From: Jonathan Rodwell [REDACTED]
Sent: 29 September 2013 15:58
To: Simon Davis
Subject: RE: FP/140/13/T 29 Links Avenue Felpham PO22 7BL

Subject: RE: FP/140/13/T 29 Links Avenue Felpham PO22 7BL

T2 - COMMON LIME  
- RE-POLLARD

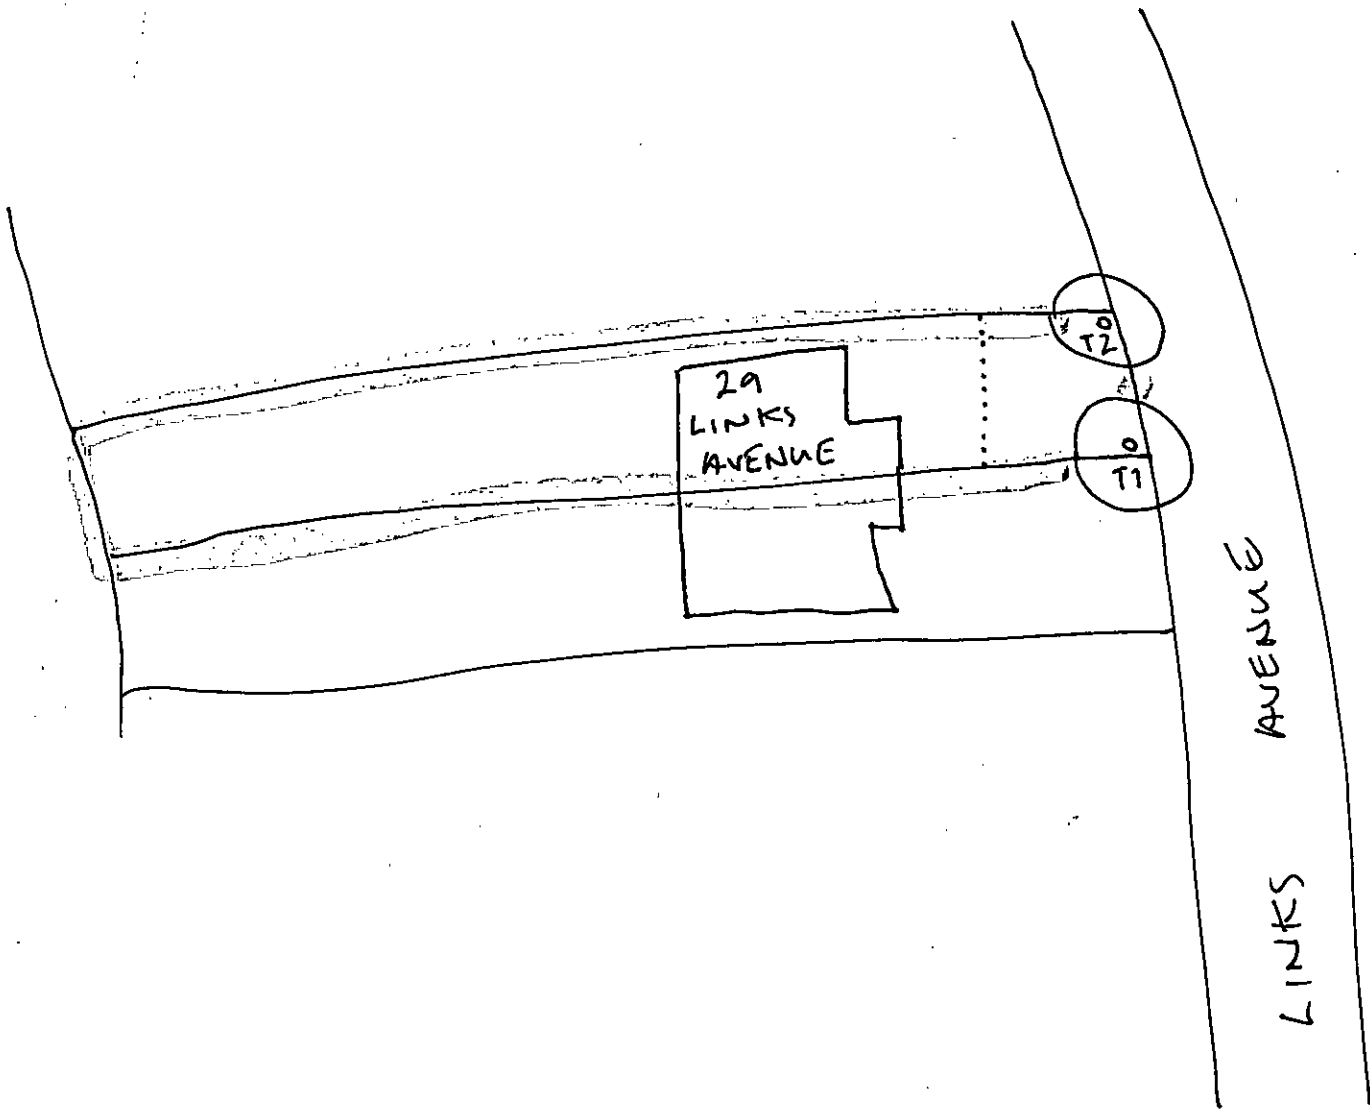
Further to the comments forwarded by my team leader Daniel Vick, I wonder if your client will agree to the amended works to T2? If so, could you reply to me in writing (by email) indicating your agreement to an amended description of say "T1 Common Lime: re-pollard at 6m above ground level removing 9m of crown above the Pollard; and "T2 Common Lime: reduce crown by 5m". Then I will proceed to issue the decision. Otherwise I will have to refuse the works to T2.

I confirm that I am happy to amend the description of works to the common lime (T2) to:

"Reduce crown by 5m."
